Appendix A19 – TSC Pre-lodgement Meeting Minutes

Proposal: State Significant Development SSD-10398 for expansion of the Hanson's Sand Quarry (Phase 5 to 11).

SECTION C
1:150 AT A1

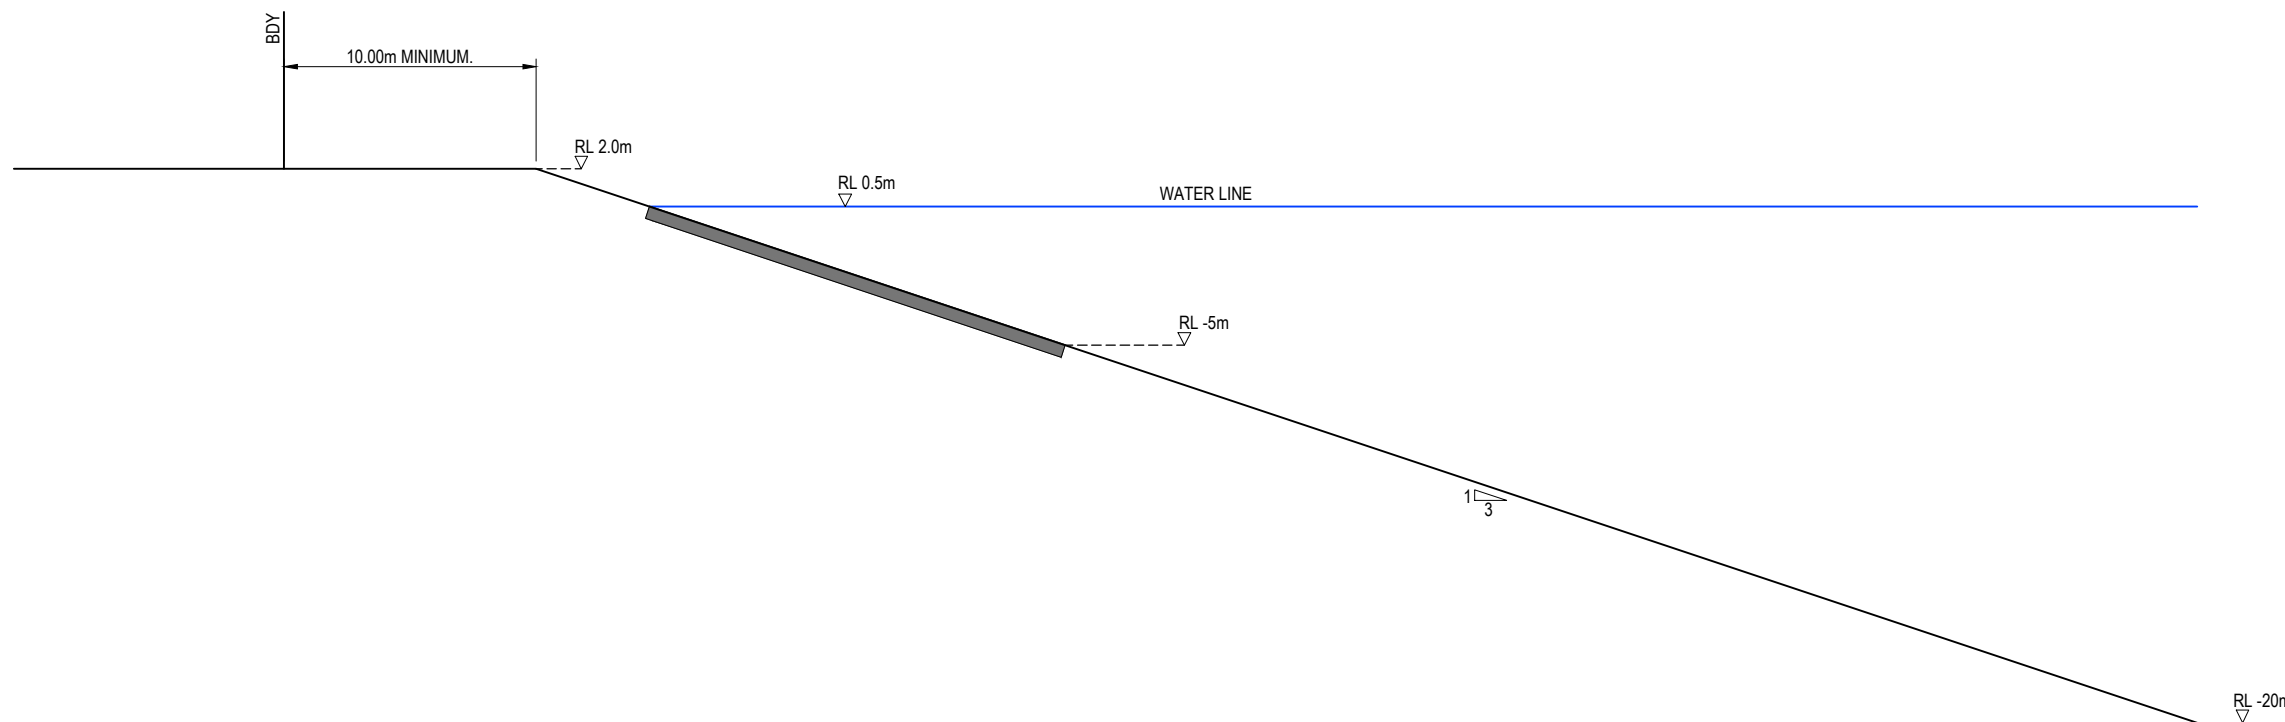
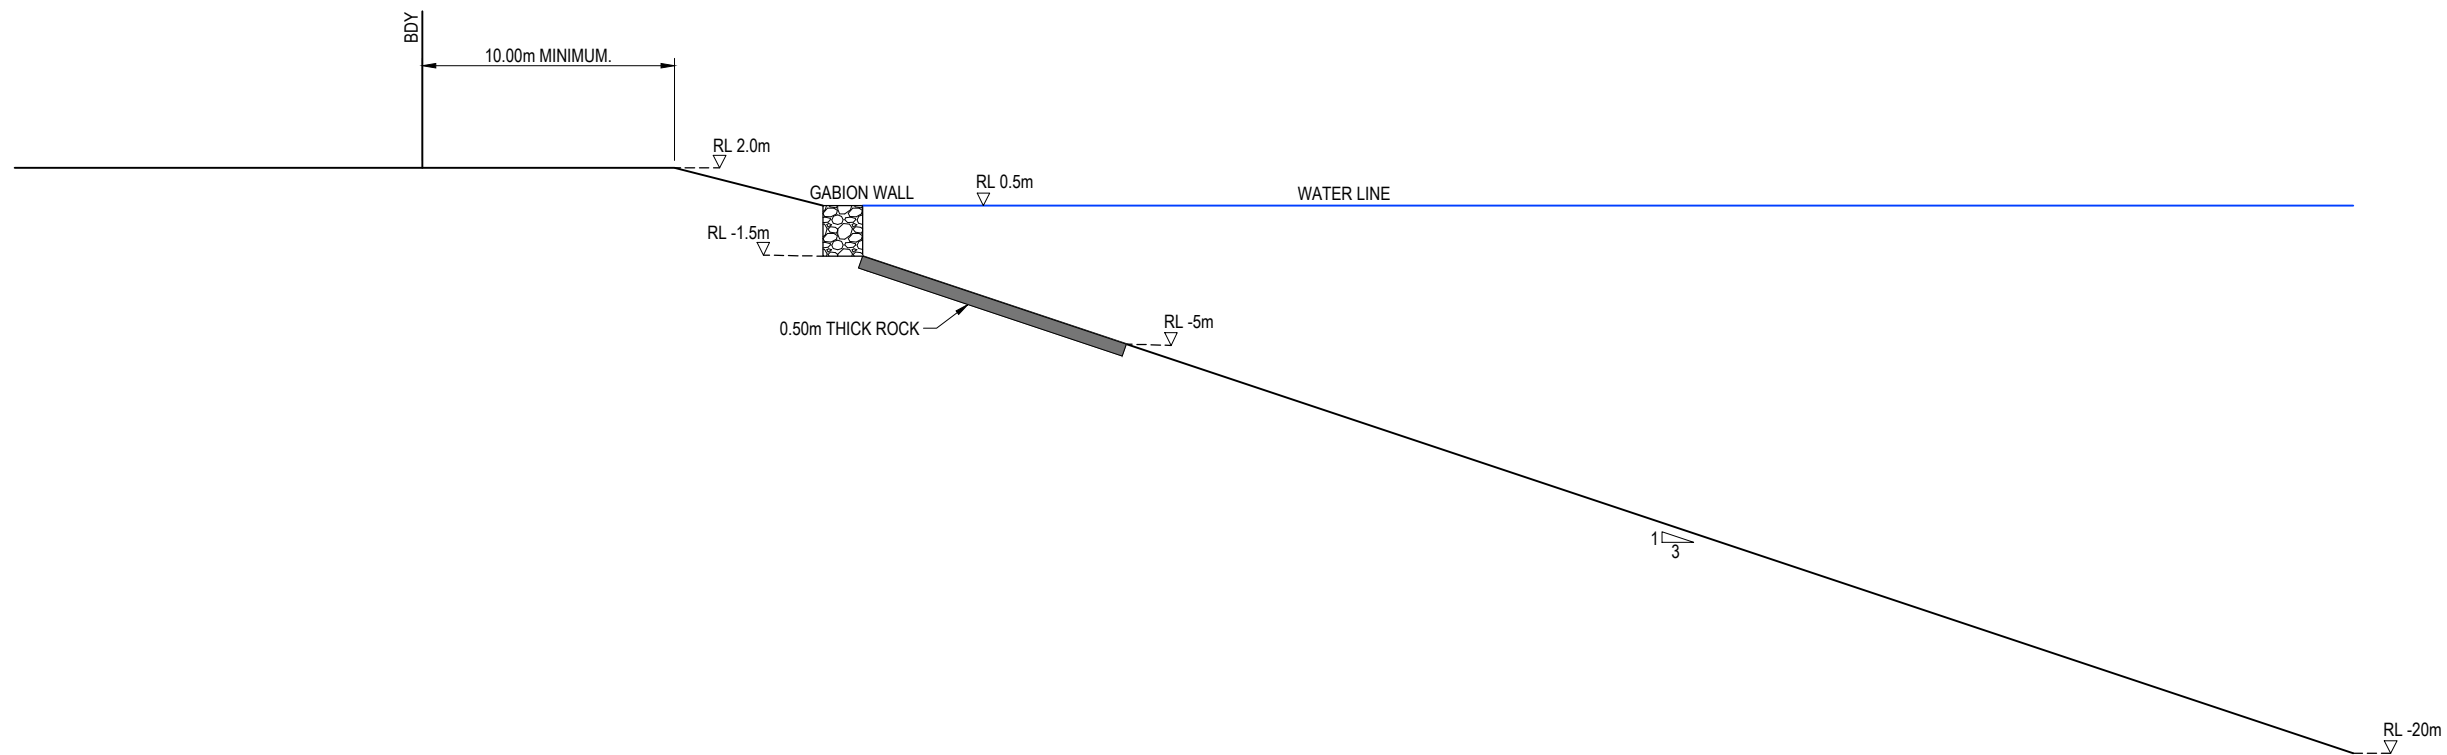
- The application should address geotechnical properties of the quarry site, including consideration of long term stability of the excavation batters, to ensure that they are designed and constructed to prevent slumping and instability on adjoining land in perpetuity.

Z19163- 104

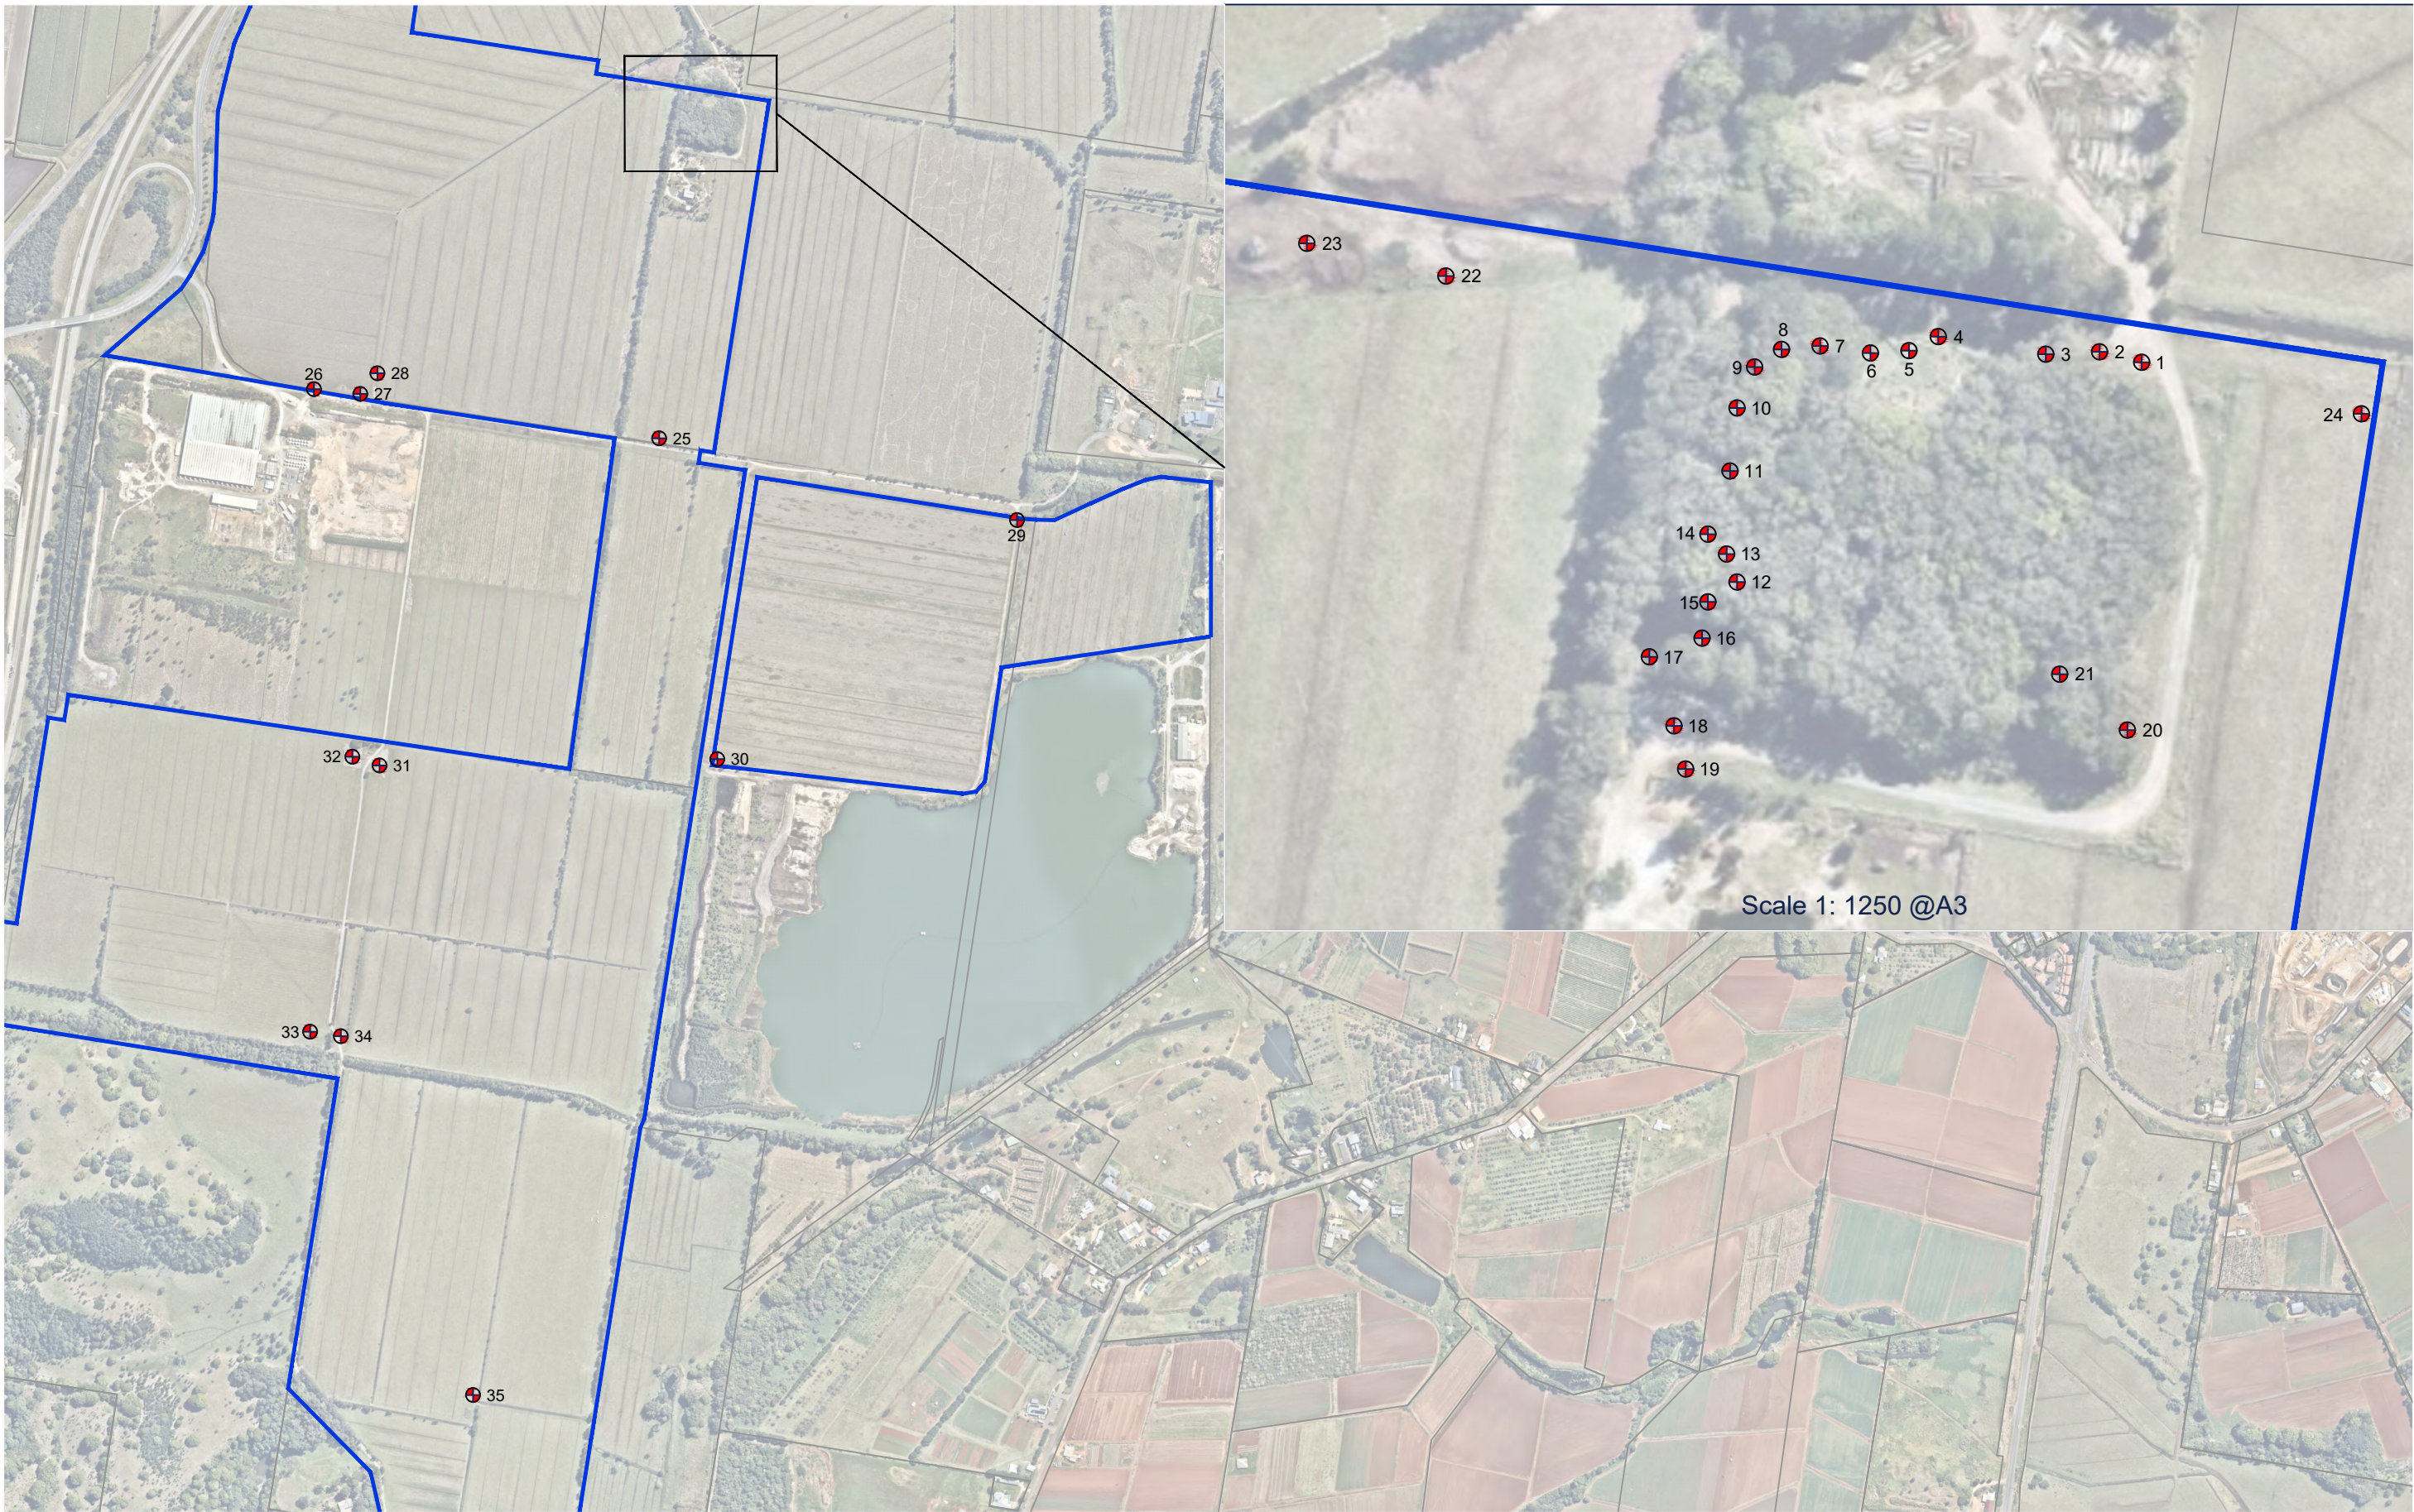
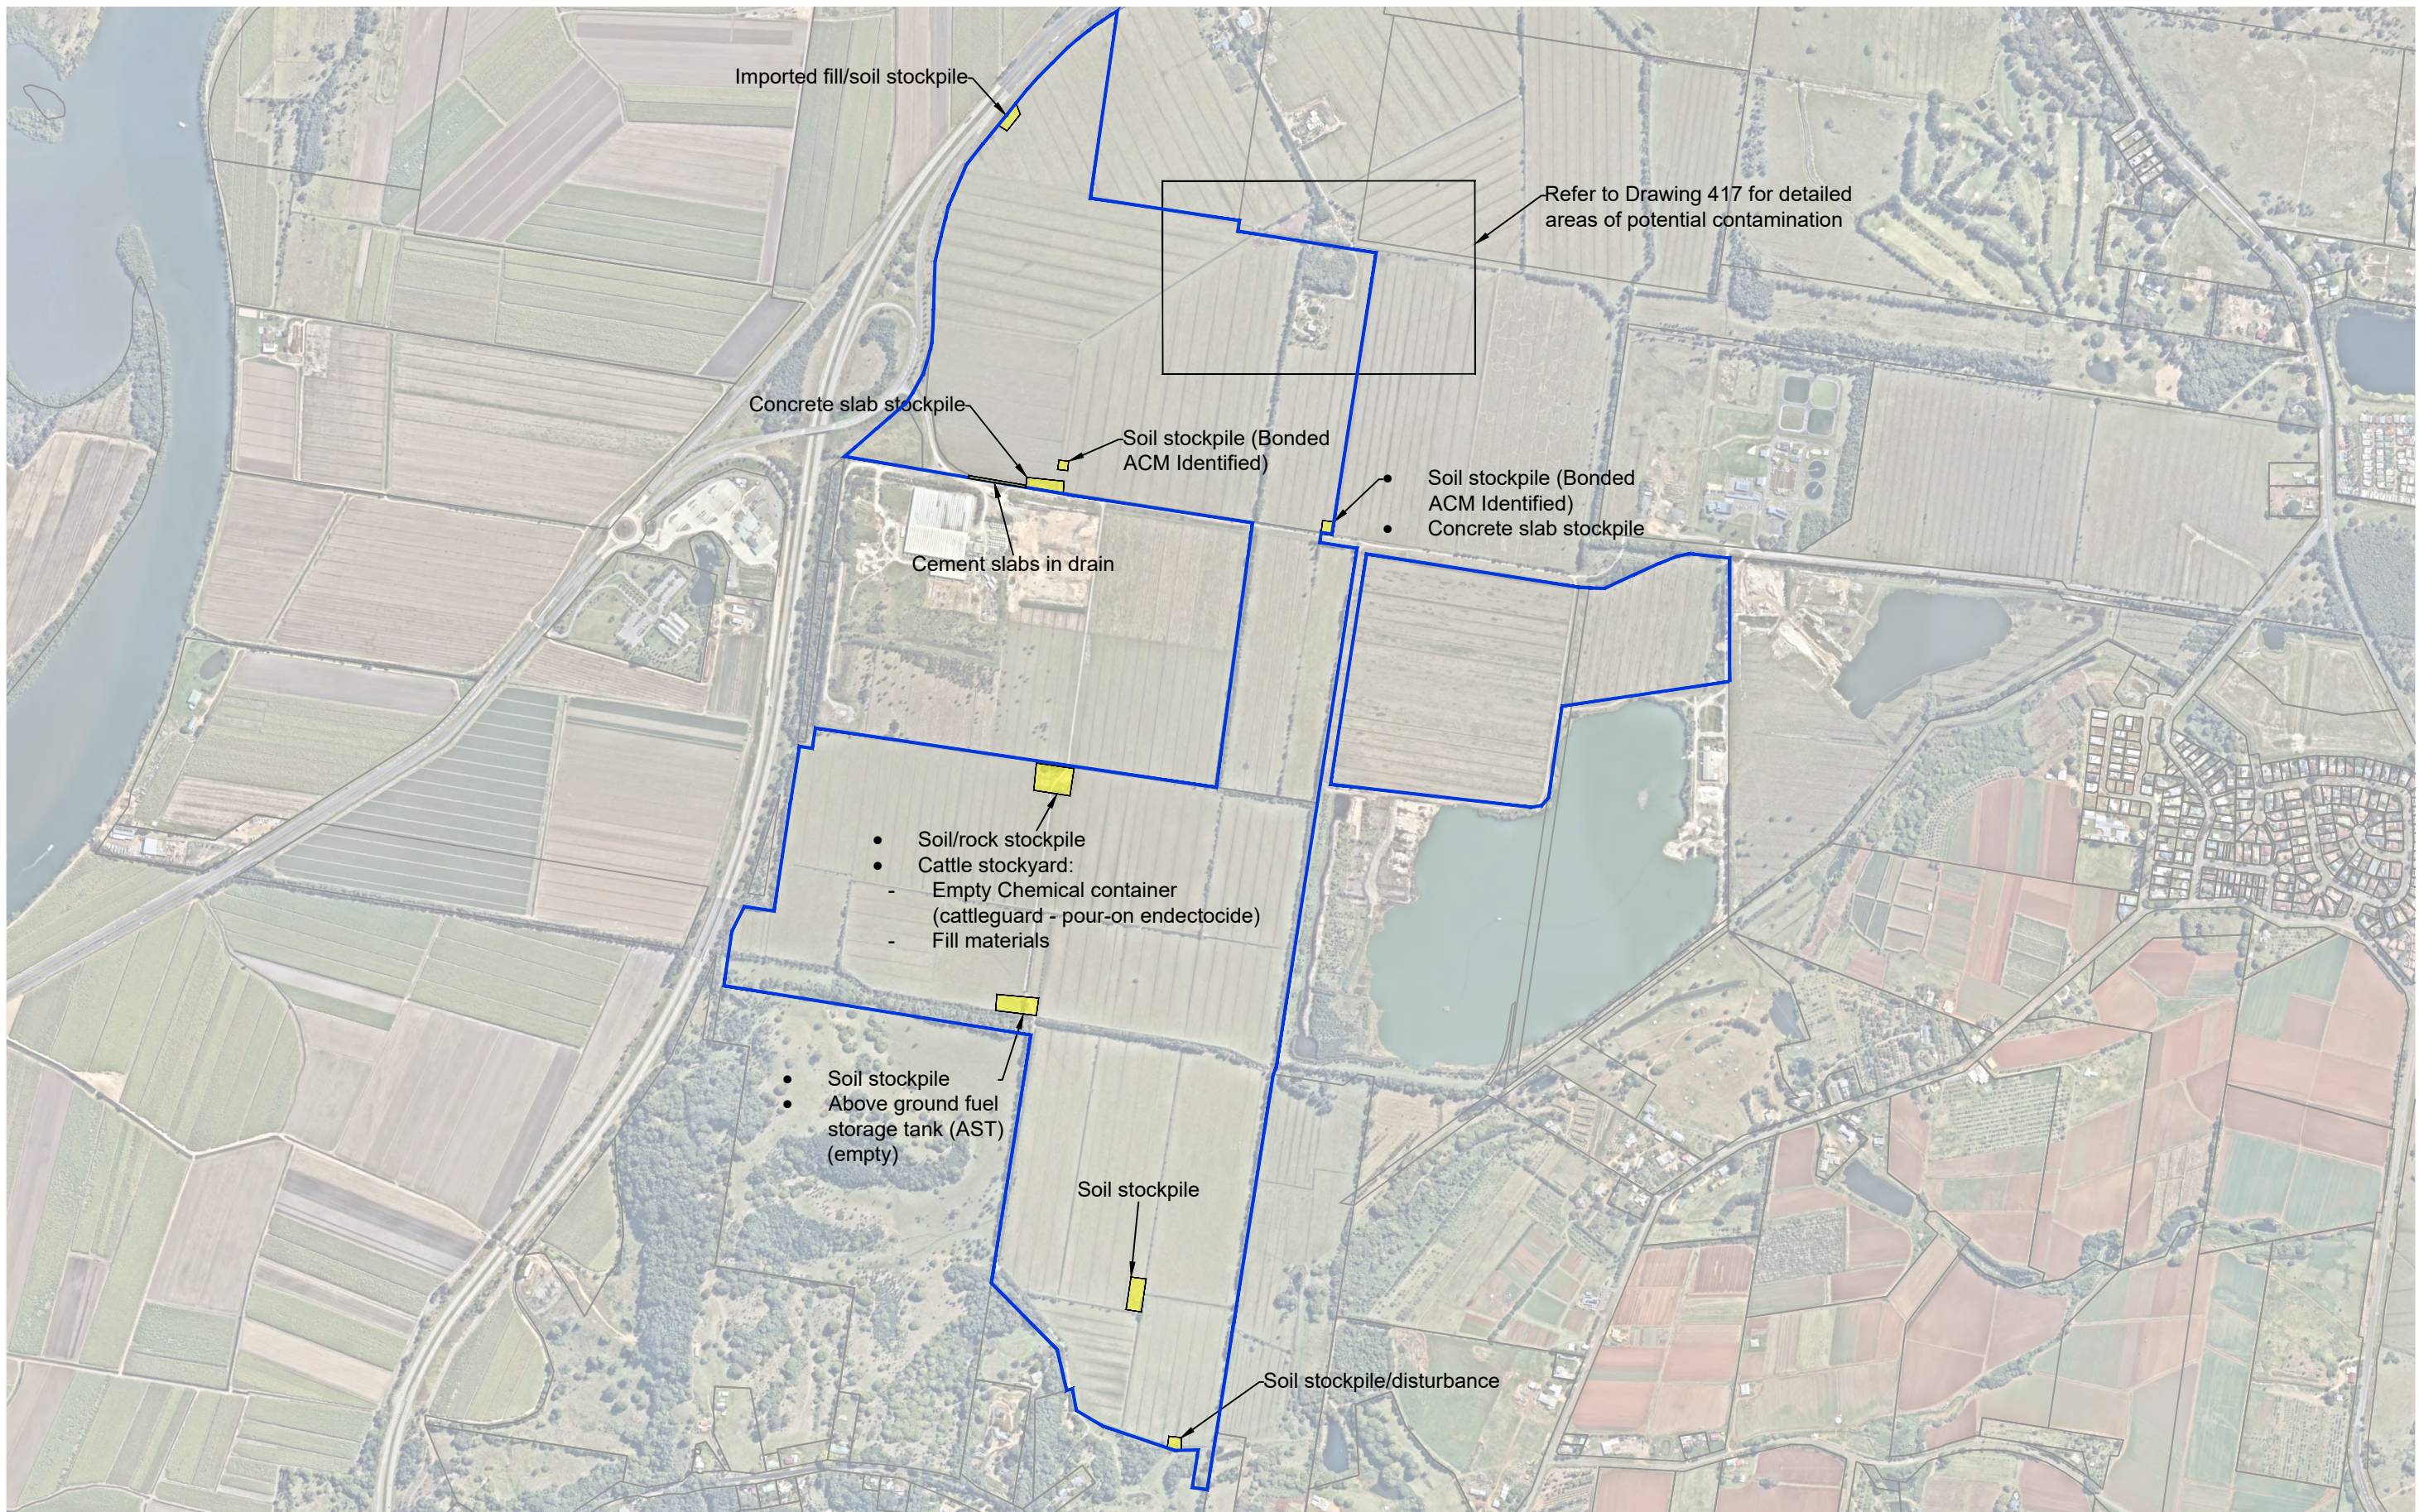
- A concept “end use” plan has been submitted for discussion at the meeting. It shows 3, potentially 4 separate lakes. Again the question of long term ownership was raised. It is reiterated that Council ownership of the lakes is not supported.
